CITY OF ALBUQUERQUE

May 23, 2022

**Re: Valley View
9368 Valley View Drive NW
Traffic Circulation Layout
Architect's Stamp 05-20-2022 (C13-D036)**

Sheet: Traffic Circulation Layout

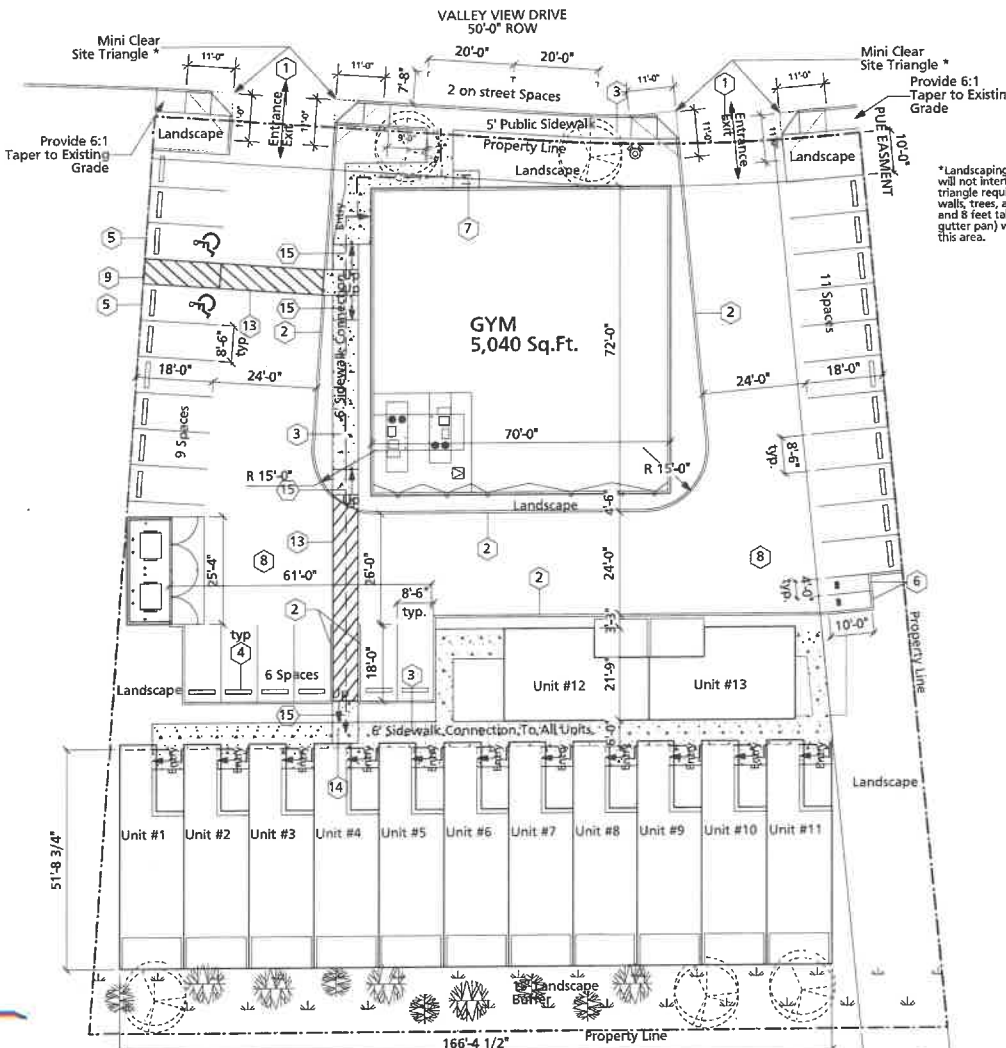
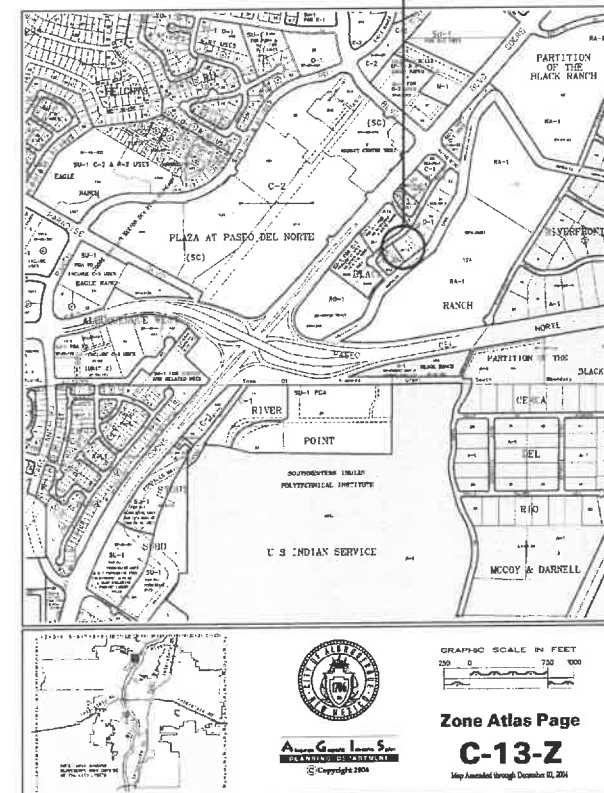
1. The proposed 6 ft sidewalk and driveway ramp are in conflict. **Please clear this safety concern since sidewalk is parallel to drivepad ramp, it will cause a tripping hazard.**
2. The 6ft sidewalk pathway adjacent to complex sidewalk will need a ramp to connect to each other. What do you mean by UP? The portion on the sidewalk needs to be @% max in both directions (at the complex stalls/sidewalk connection).
3. Please provide a letter of response for all comments given.
